# CITY OF ALBUQUERQUE

RE: **Aloha RV Expansion**  
**8212 Pan American Fwy NE**  
**Grading and Drainage Plan**  
**Engineer's Stamp Date: 5/7/19**  
**Hydrology File: C18D104**

Based on the submittal received on 5/8/19, the Grading and Drainage Plan cannot be approved until the following are corrected:

EROSION AND SEDIMENT CONTROL PLAN

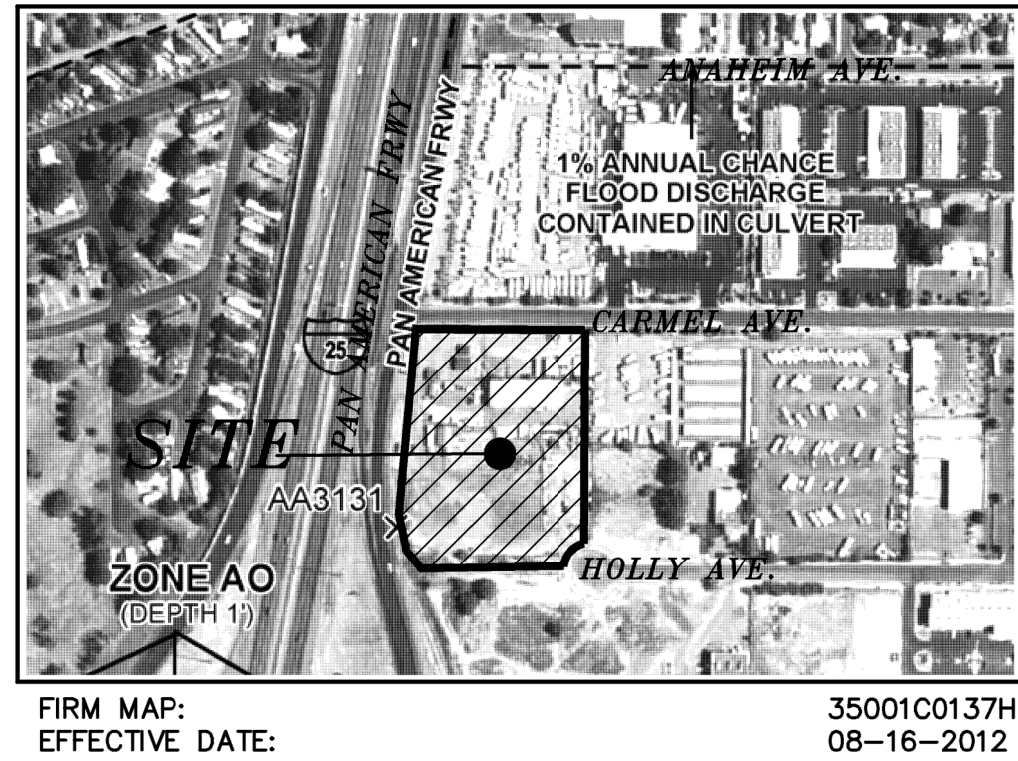
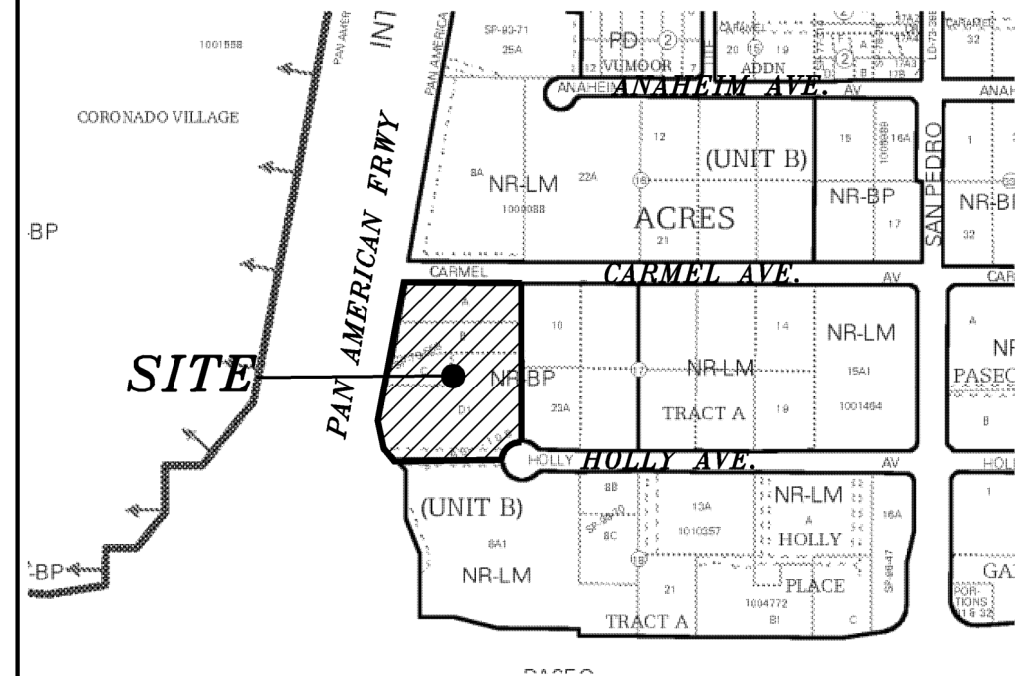
1. Bernalillo County Recorded [Drainage Covenants \(No Public Easement\)](#) are required for the storm water control ponds. The original notarized form, exhibit A (legible on 8.5x11 paper), and recording fee (\$25, payable to Bernalillo County) must be turned into DRC (4th, Plaza del Sol) for routing. Please contact Charlotte LaBadie (clabadie@cabq.gov, 924-3996) or Madeline Carruthers (mtafoya@cabq.gov, 924-3997) regarding the routing and recording process for covenants. The routing and recording process for covenants can take a month or longer; Hydrology recommends beginning this process as soon as possible as to not delay approval for Grading Permit. Because there is no Certificate of Occupancy for this work, the covenant needs to be recorded first. Our legal department reviewed the new ordinance and decided the language doesn't provide sufficient warning to the property owner (or future property owners); a recorded covenant is still required.

2. Provide recorded crosslot drainage easements across all affected parcels, prior to grading Permit. Alternatively, these lots could be consolidated (re-platted) to remove the need for easements.
